Re: M/94/17/PL 72 Ancton Way Bognor Regis PO22 6JP

**N265 – 72 Ancton Way Bognor Regis PO22 6JP
October 2017**

In response to objections raised to the planning application ref: M/94/17/PL – (Demolition and erection of 1 no. dwelling with integral garage) we would like to address the following points.

Proposed Site Plan

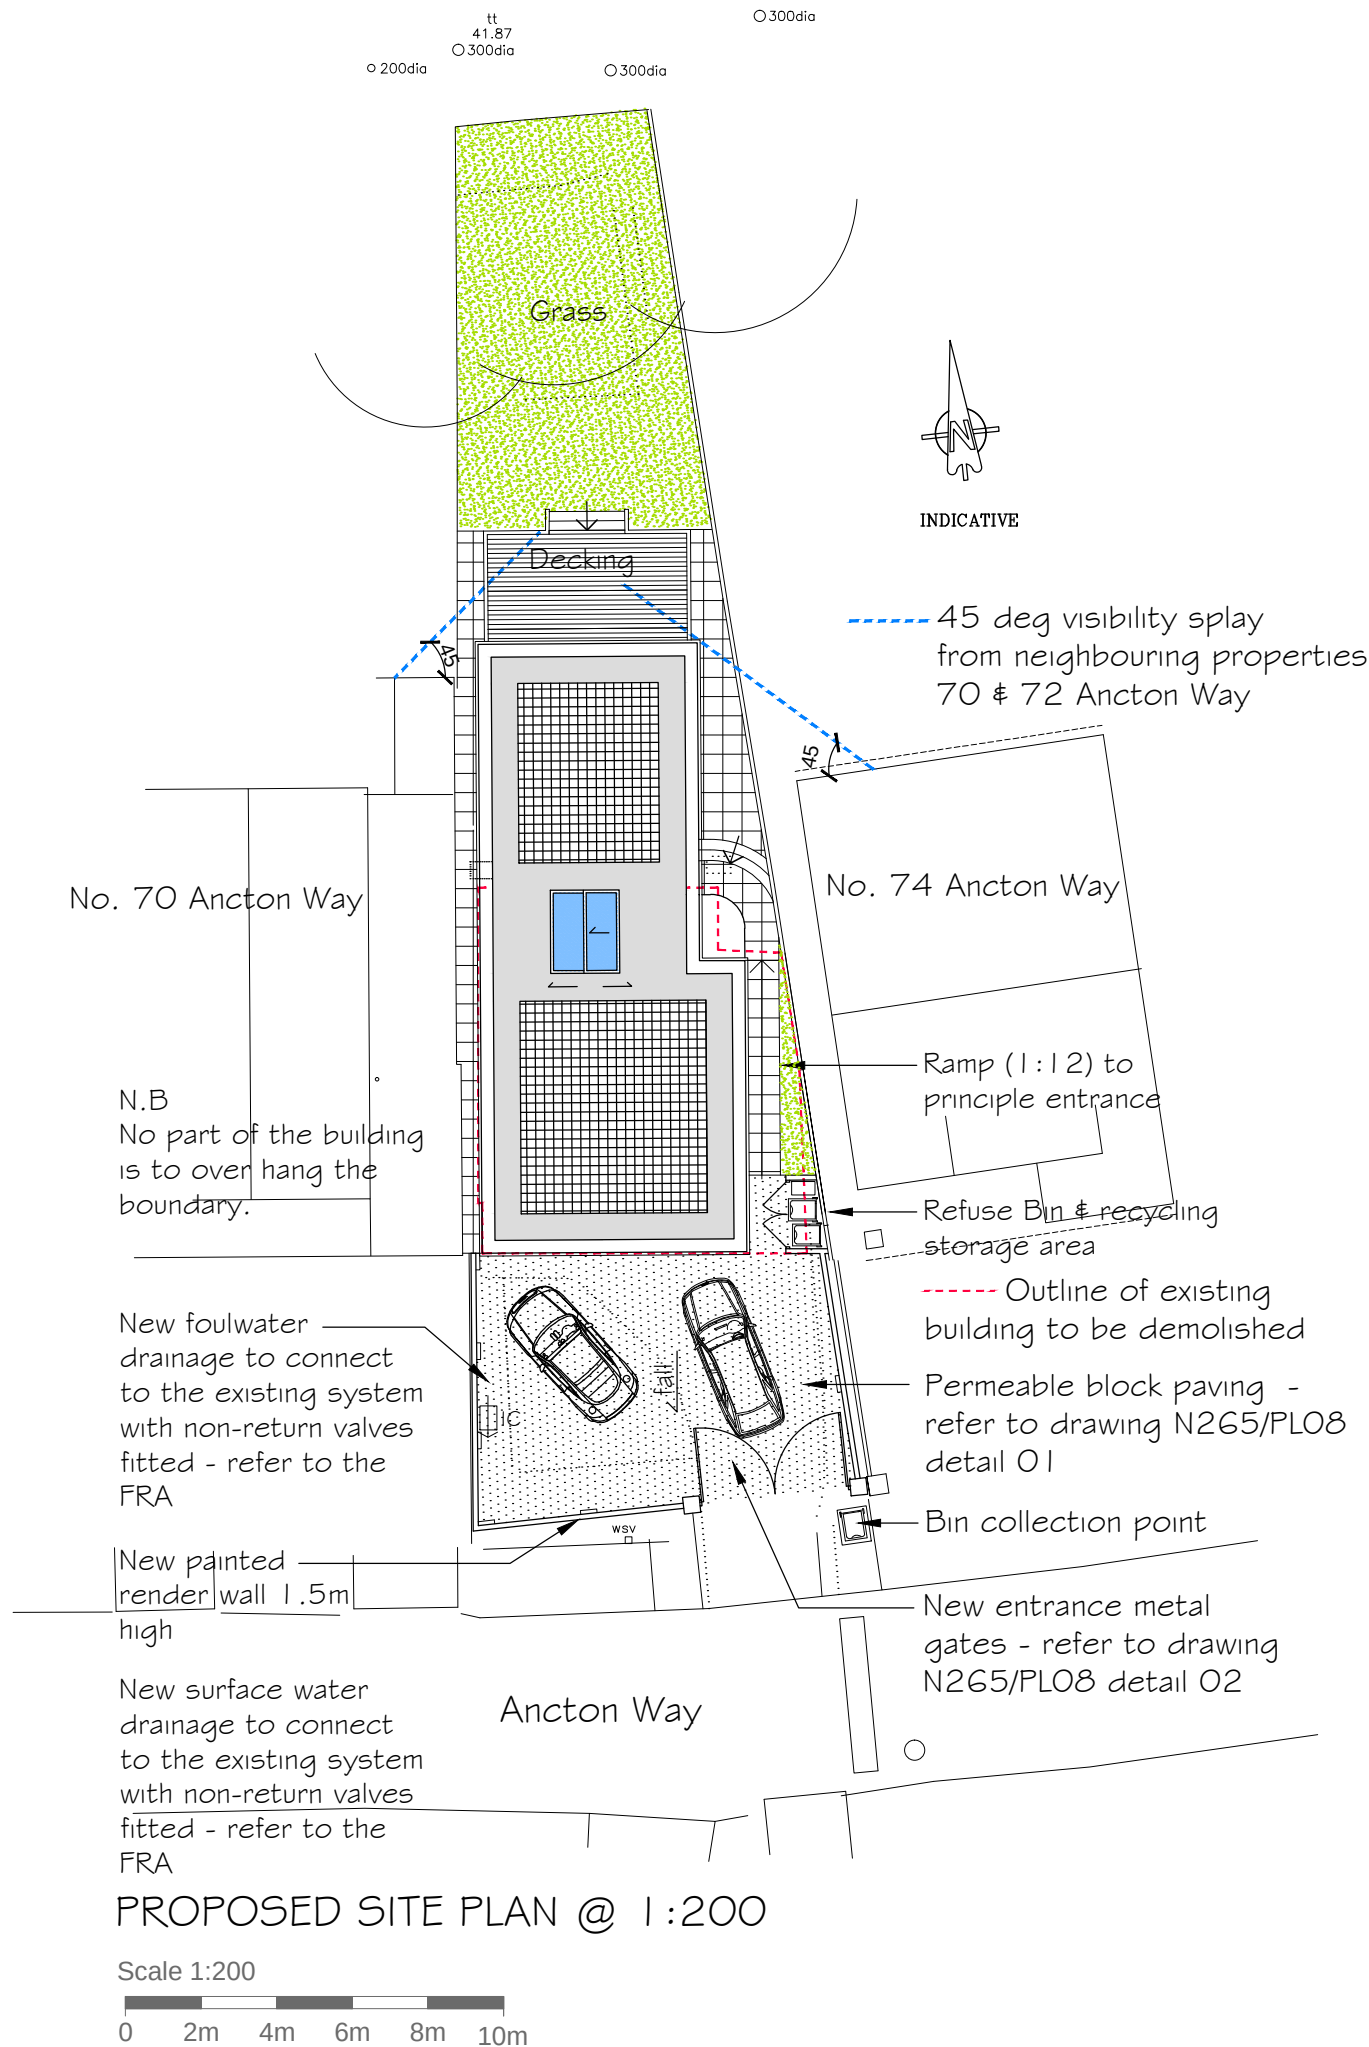
4) Proximity of building to boundary

Below is an extract of the site plan N265/PL02 which shows the existing building footprint highlighted in red. This shows that the distance to the boundary to the west with number 70 is no worse than the current situation and the boundary to the east with number 74 is greatly improved with over 1m at the narrowest point. Building close to the boundary does have its complications but it's nothing that a competent builder cannot overcome which is evident by the number of buildings on or near the boundary shown in the photographs below.

Proposed Elevations
(1 of 2)

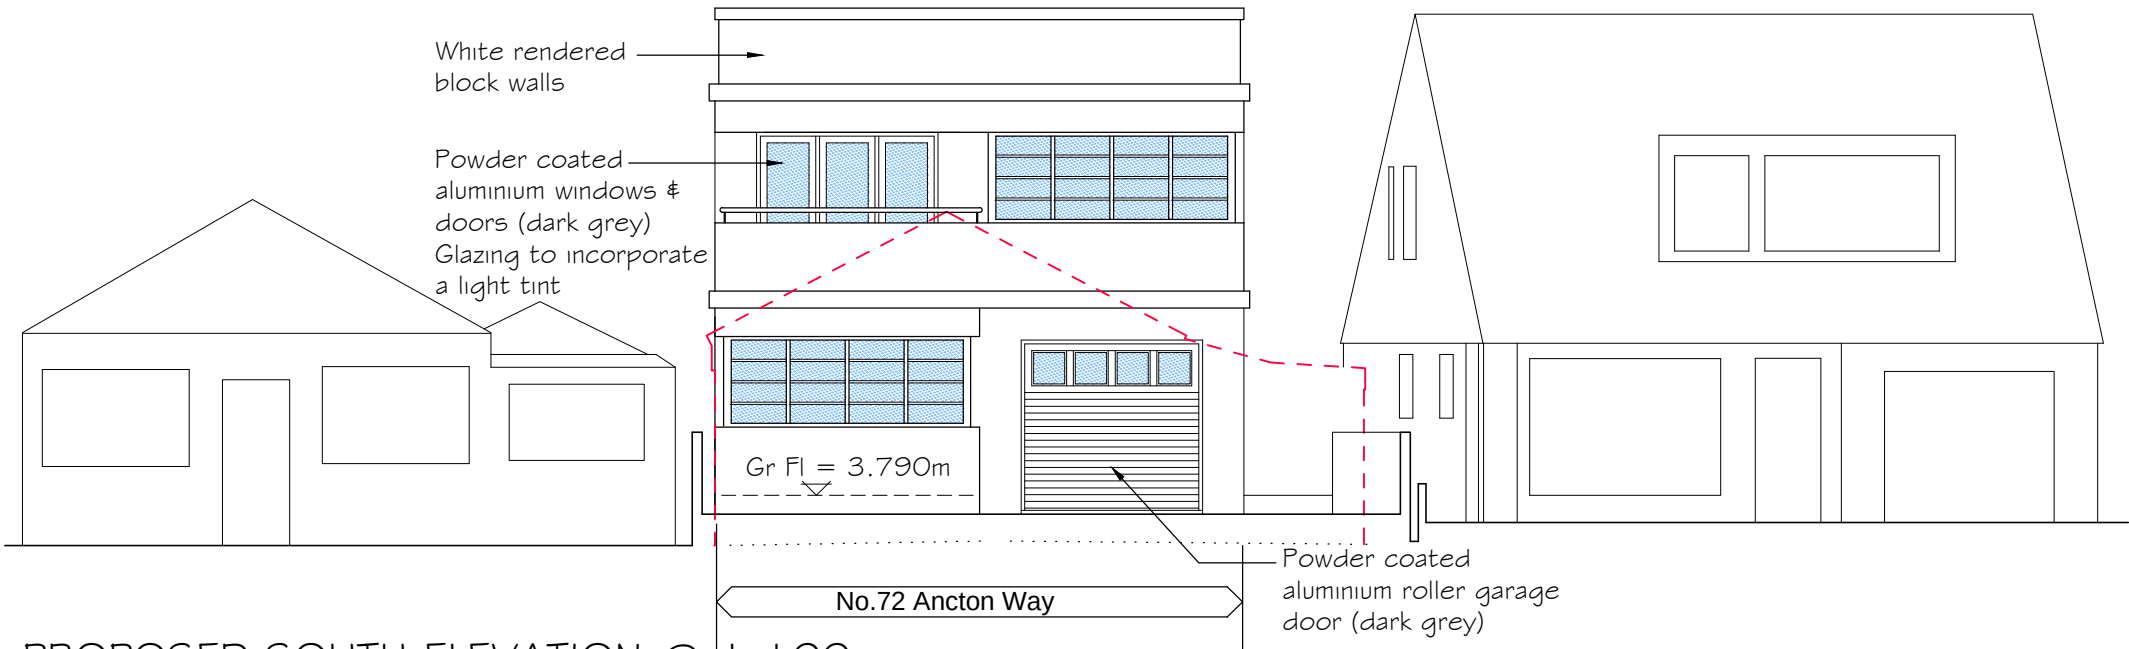
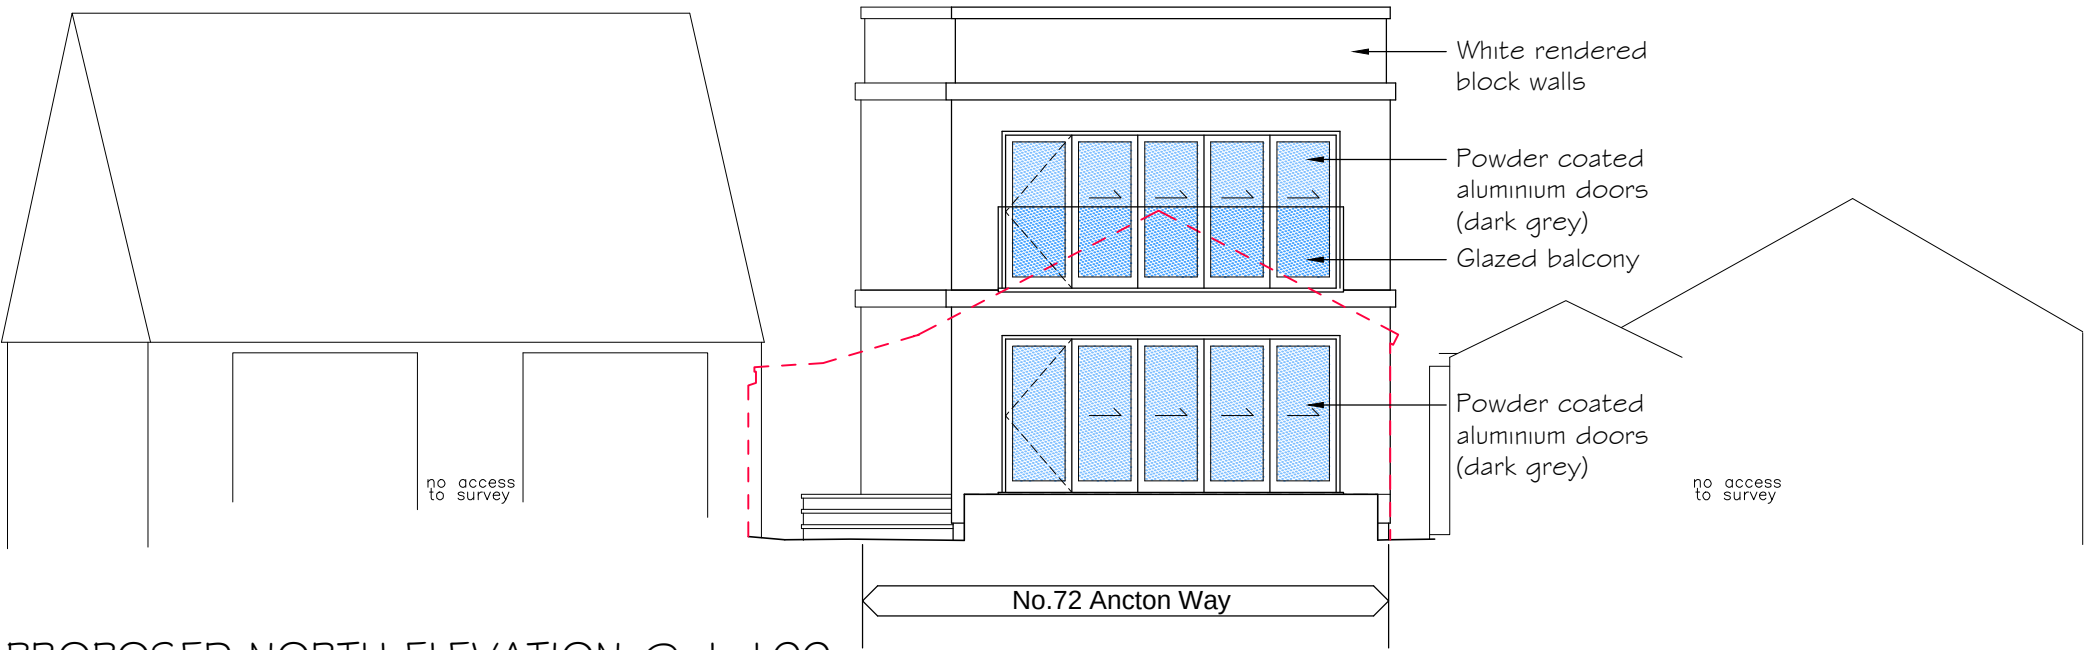
2) Full height doors to the first floor rear elevation.

3) Balcony to the front elevation.

The doors offer no greater opportunity for overlooking than windows would on this elevation. Doors have been incorporated to maximise light into the room and are in proportion to the size of the room. There is limited opportunity on the side elevations for windows in terms of planning (overlooking/privacy) and building regulations (Approved Document B Fire regulations).

The Balcony has been incorporated to the front elevation to break up the mass of the building and is characteristic of this style of architecture. In terms of overlooking balconies to the front elevation are deemed to be less intrusive as those to the rear. Front gardens in most cases are open to public view and it is therefore not so critical in terms of protecting the occupier’s privacy. The photographs below show numerous examples of balconies to the front elevation.

PROPOSED SOUTH ELEVATION
SHOWING FRONT BOUNDARY
AND GATES @ 1:100

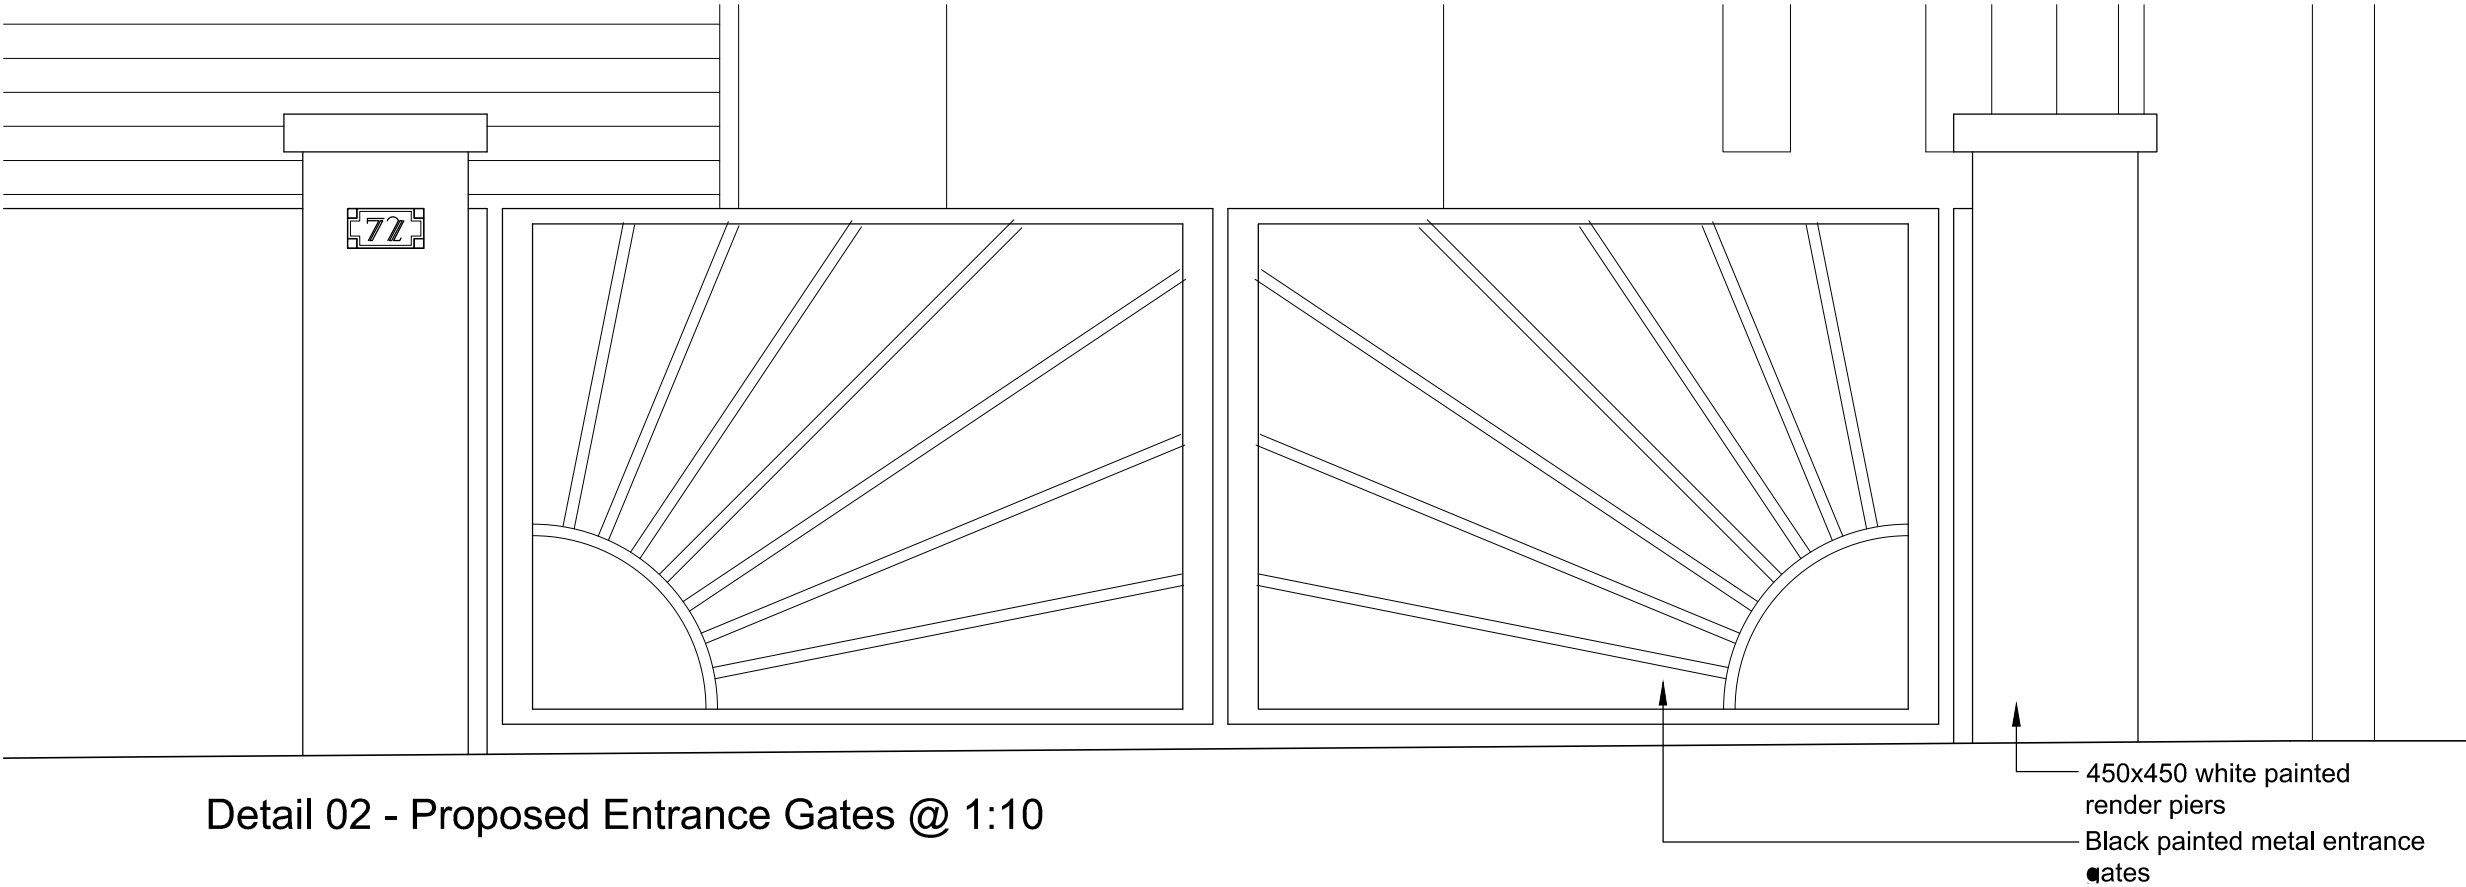
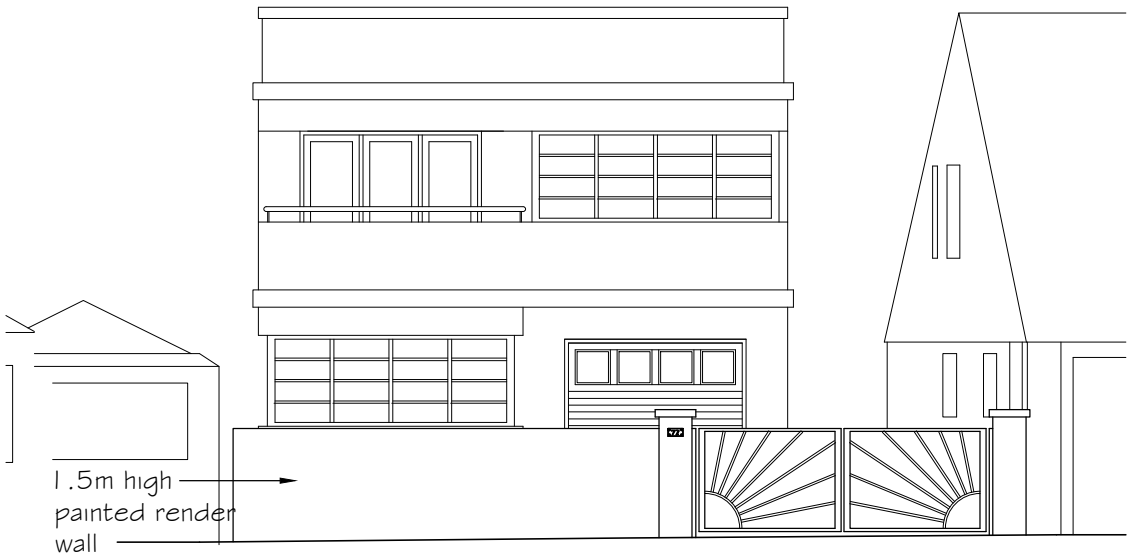
5) Boundary wall

The boundary wall to the front elevation is to provide a degree of security and other examples of a similar height wall are noted locally as shown in photographs 11B & 29 A below.
